RE: **GAHP Silver Downtown**
800 Silver SW
Grading Plan Engineer's Stamp Date: 2/21/2017
Hydrology File: K13D013

RE: **GAHP Silver Downtown**
800 Silver SW
Grading Plan Engineer's Stamp Date: 1/30/2017
Hydrology File: K13D013

Based upon the information provided in your submittal received 2/10/17, the Grading Plan is not approved for Building Permit. The following comments need to be addressed for approval of the above referenced project:

D2 ENLARGED GRADING PLAN
1" = 10'-0"

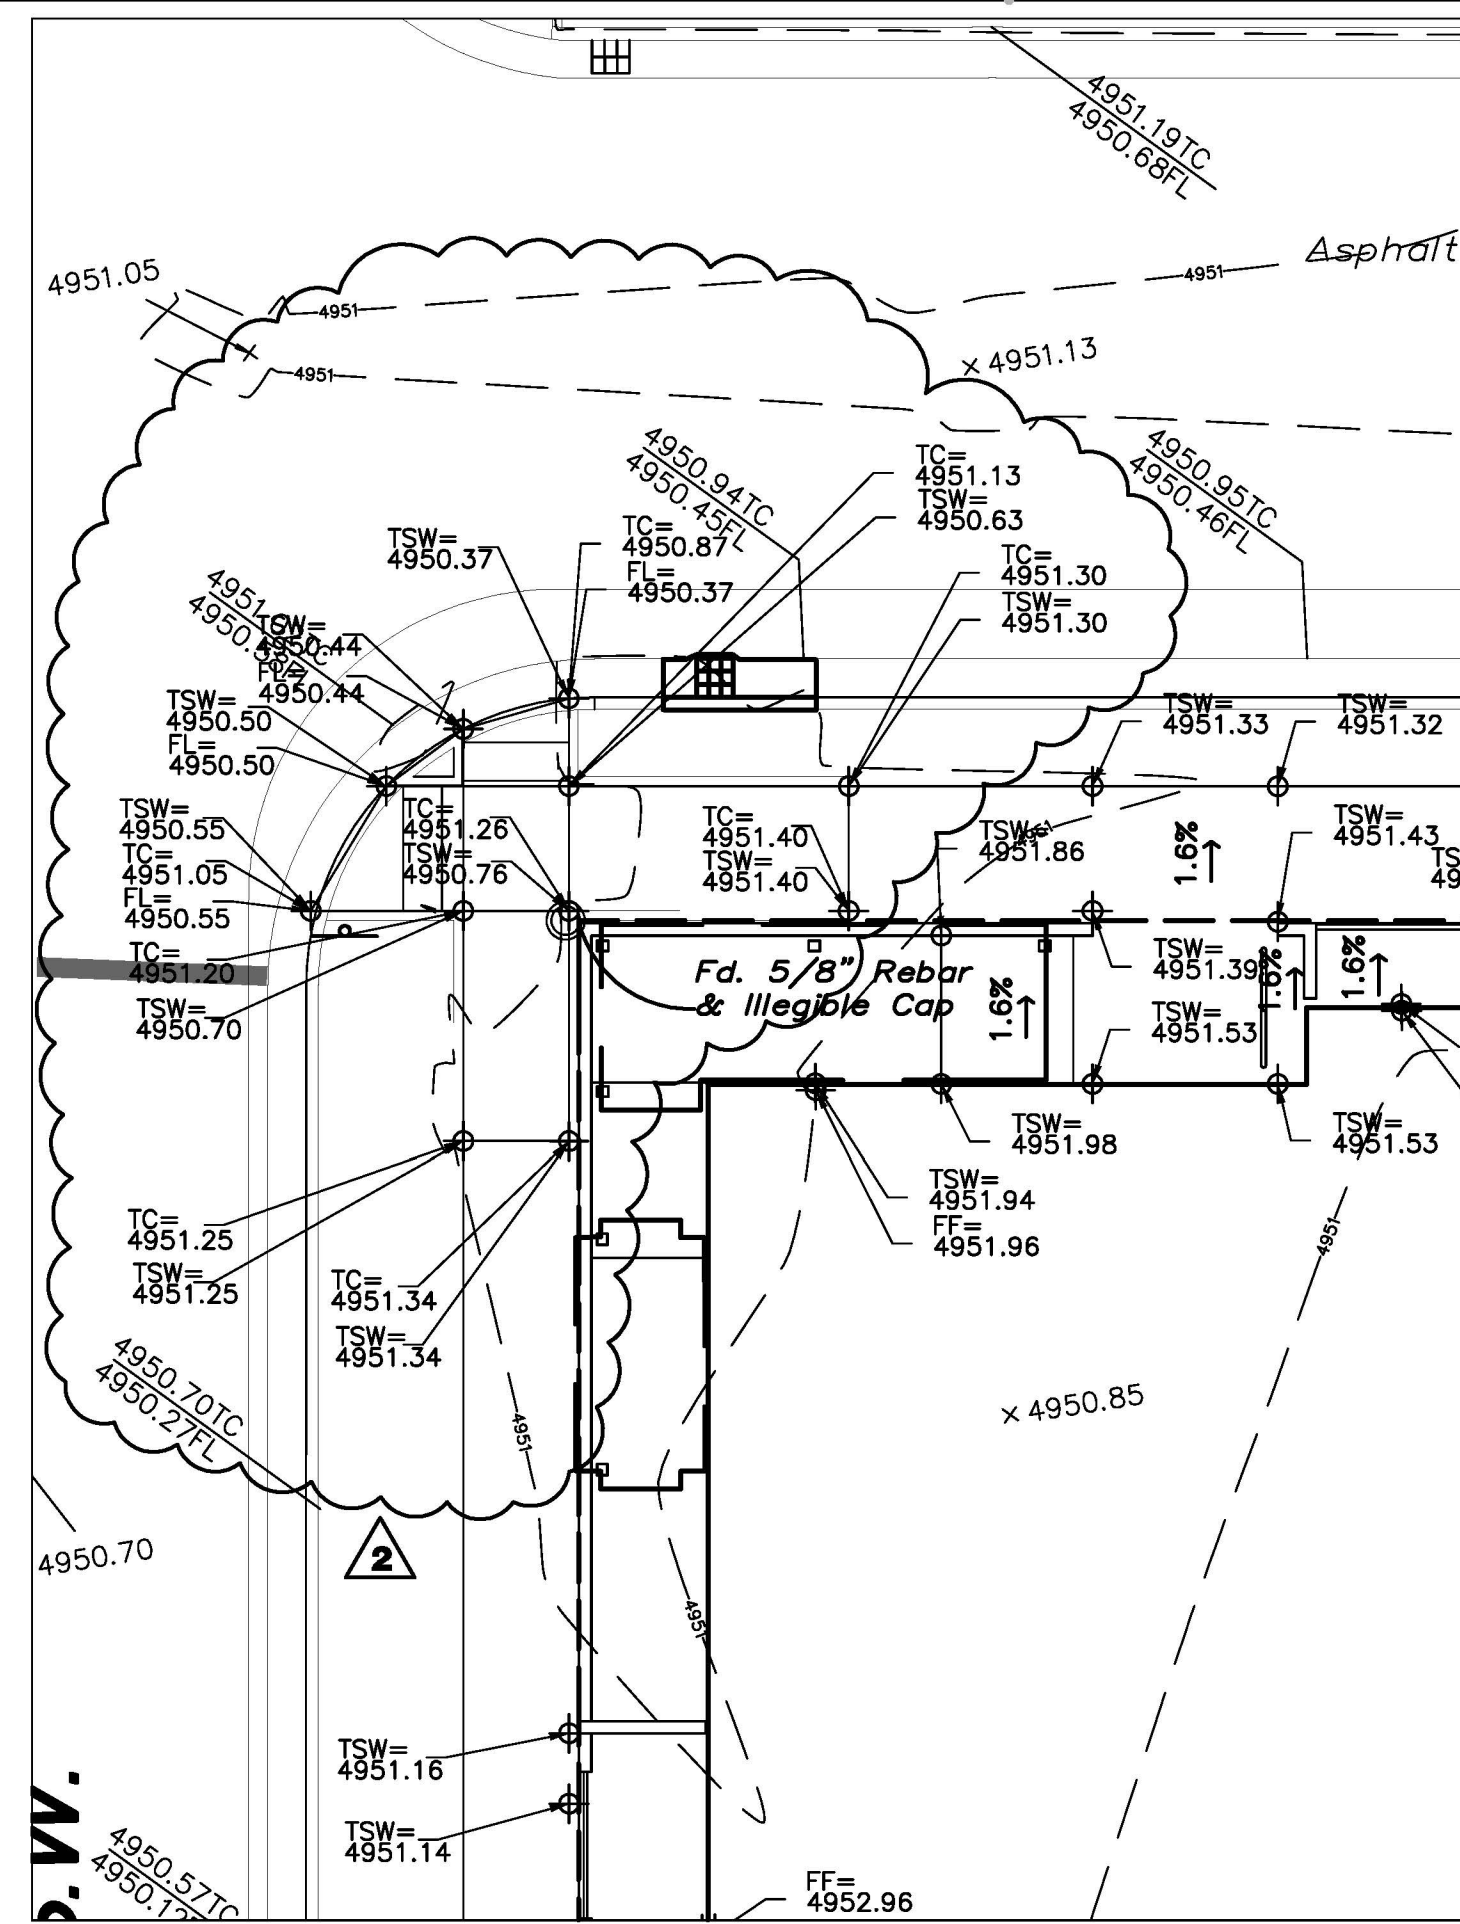
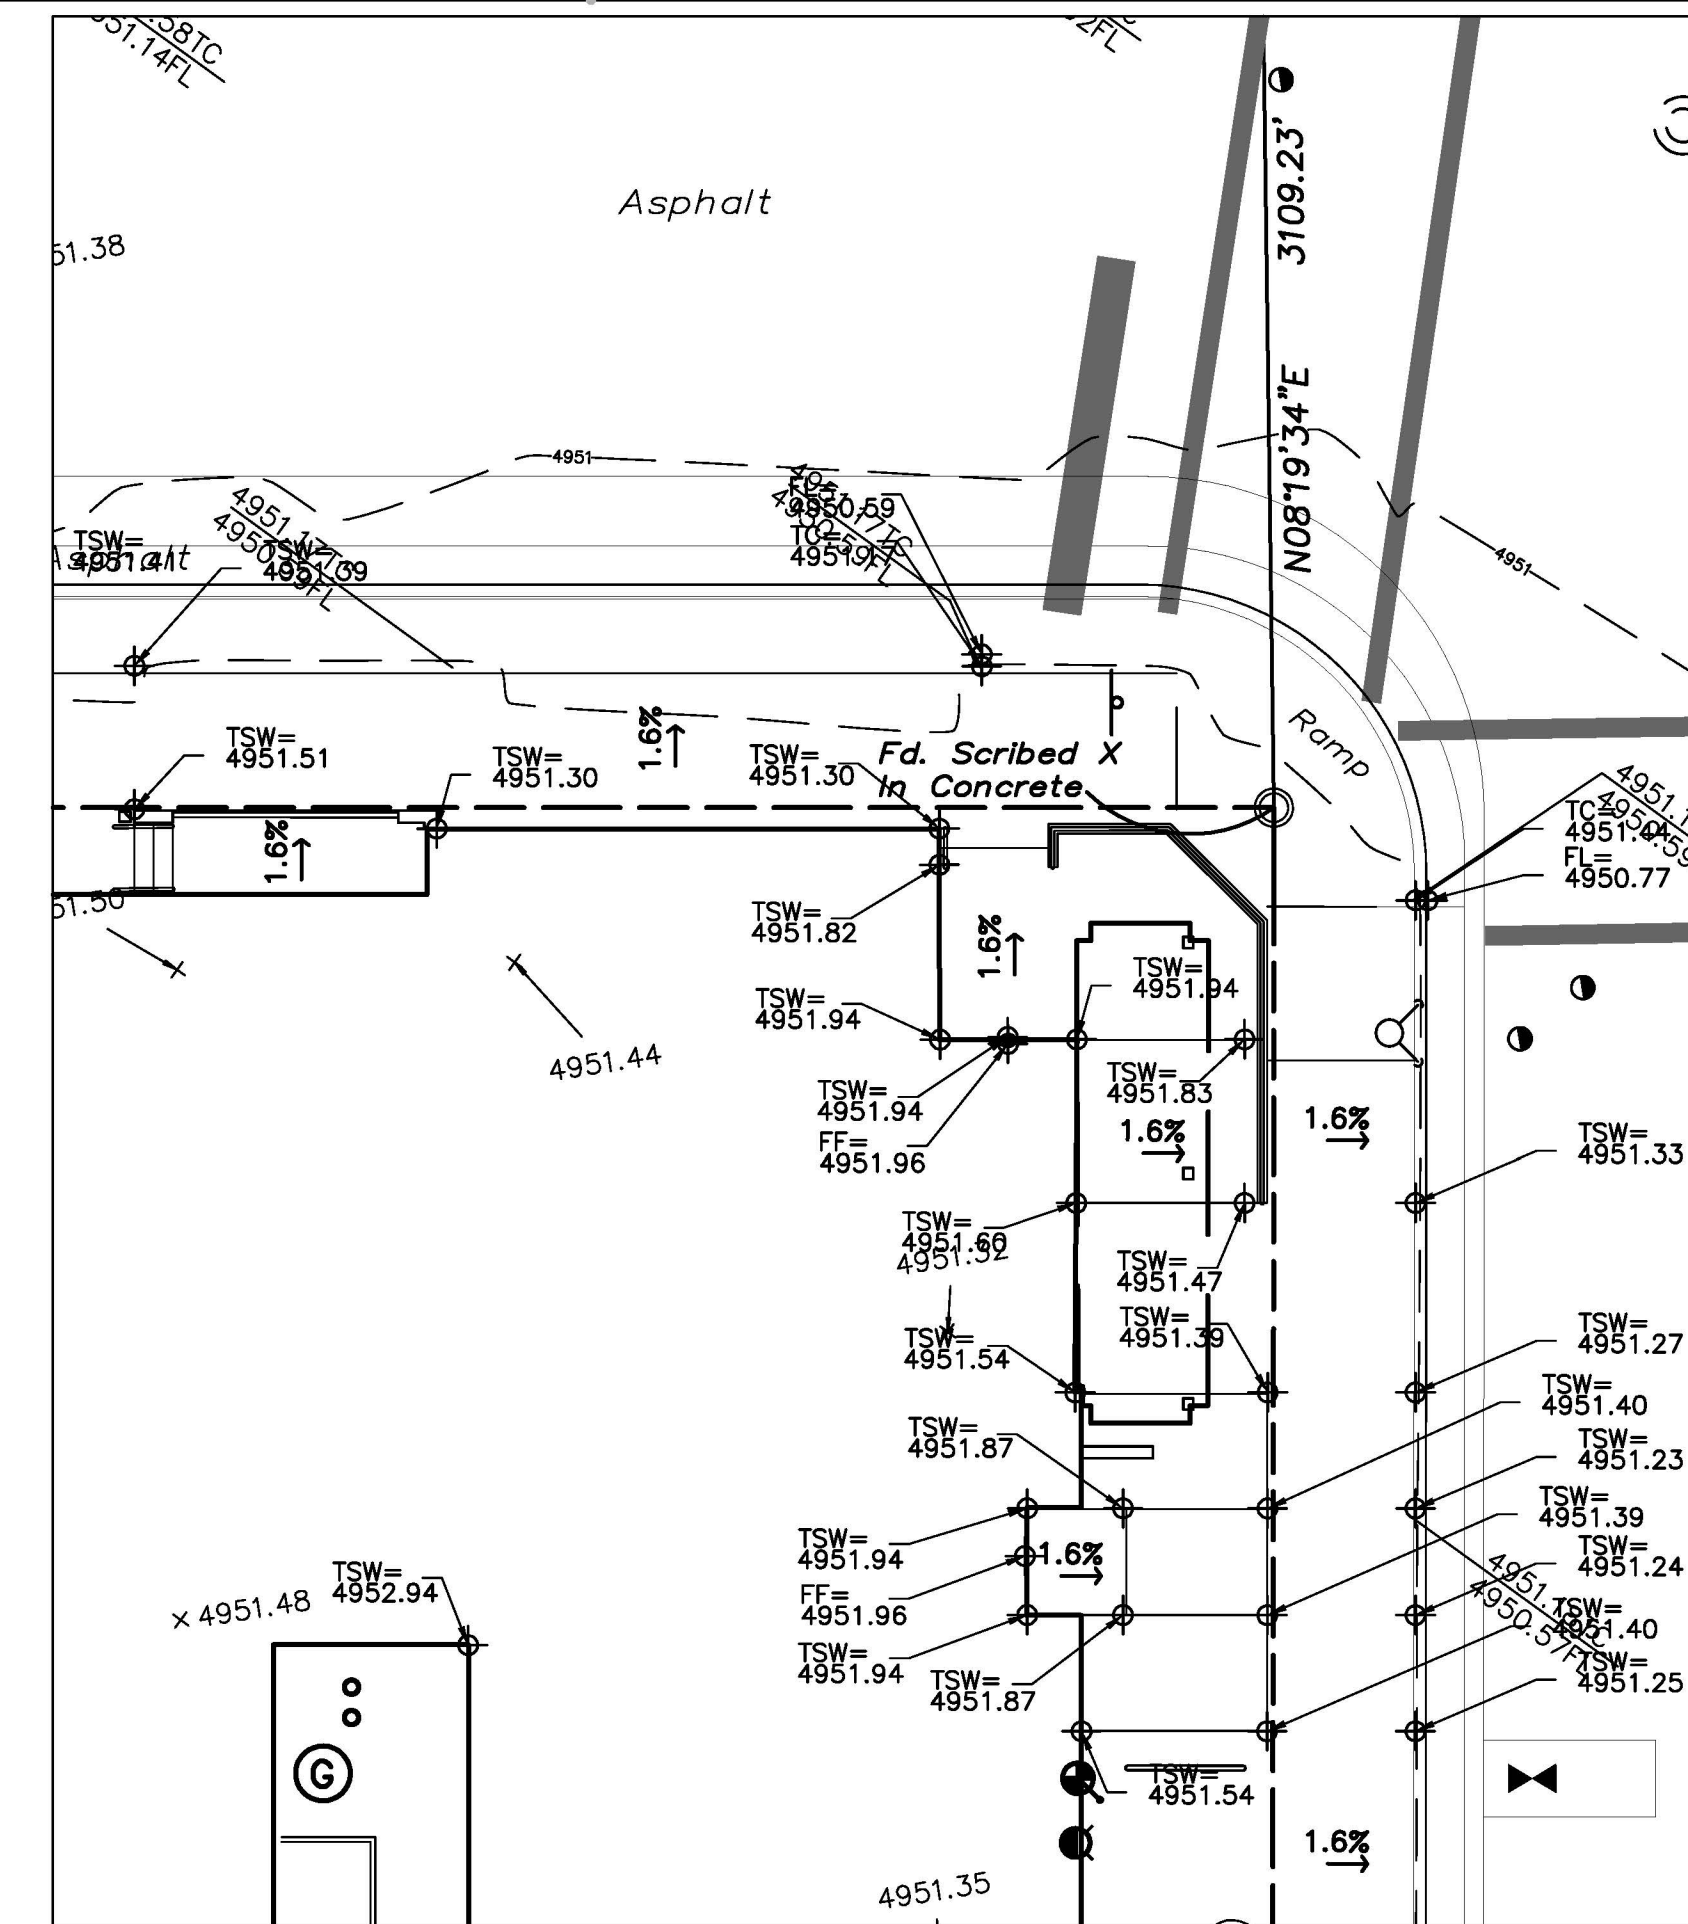
3. There is a reference to a constrictor plate for the draining the parking lot to the ally, but none is shown on the construction plans. Provide location and details for this.
Constrictor plate no longer used. Setting curb height to limit ponding.

4. It was agreed during the review for SPBP that the wide buffer between the back of curb and the edge of sidewalk would be used to help mitigate nuisance ponding on Silver and 9th Street, by including new curb cuts on the ex. curb. This would help the site achieve the capture of the first flush volume. It needs to be shown on the plan.
No longer possible due to fire marshal requests.

5. The 2" depression in the sidewalk buffer does not account for the running slope along top of curb and along the sidewalk. This means the depression will not retain a uniform 2" deep pool. This area needs to be supplemented with a 5:1 gravel filled swale and curb cuts with shallow ponding to allow in flows from Silver and 9th Street.
9th Street and Silver to have 5:1 swales.

6. The ponding volume for the parking area does not account for the running slope across the parking lot toward the ally. This means the gravel areas will not retain a uniformly deep 2" of water.
and curb opening on 9th Street.
Volumes adjusted. 5:1 slopes added.

This was adjusted to account for slope. 2" to centroid of volume retained

A5 ENLARGED GRADING PLAN
1" = 10'-0"

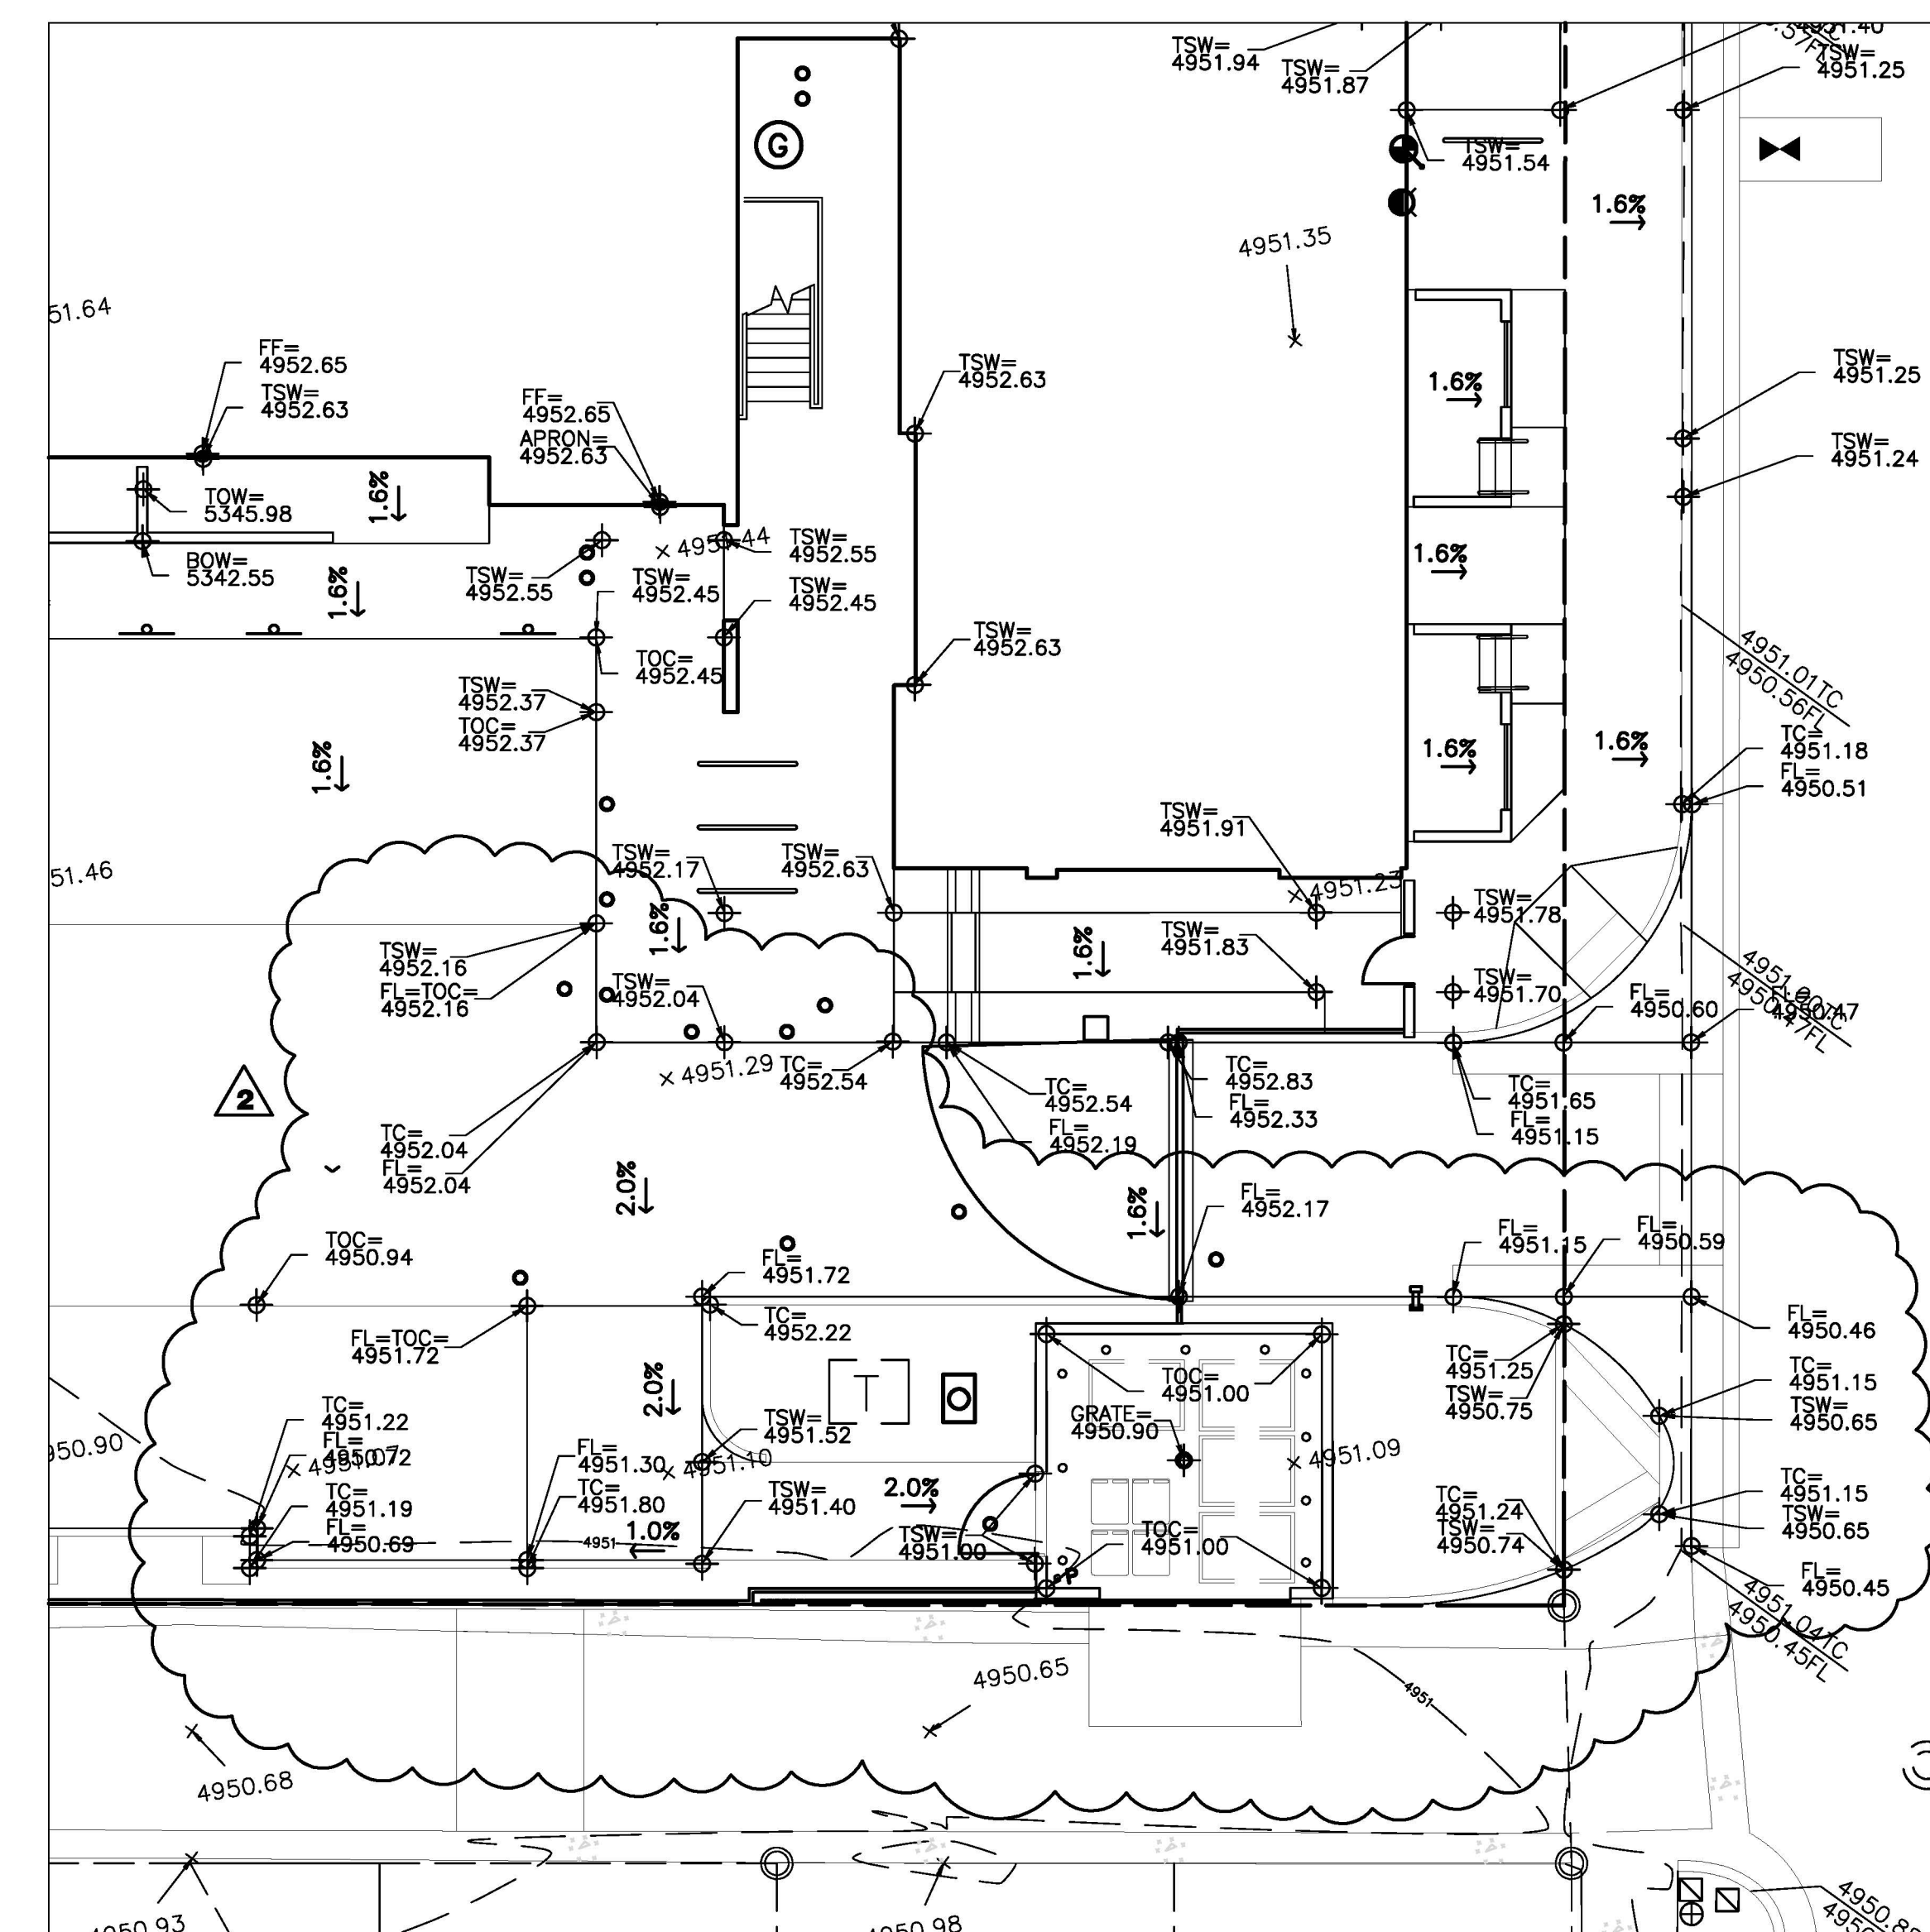
7. There is a grate elevation shown in area A5. Is there an interior storm drain network or is this to plumb the trash area into the sanitary sewer?

Notes added that this drains to sanitary
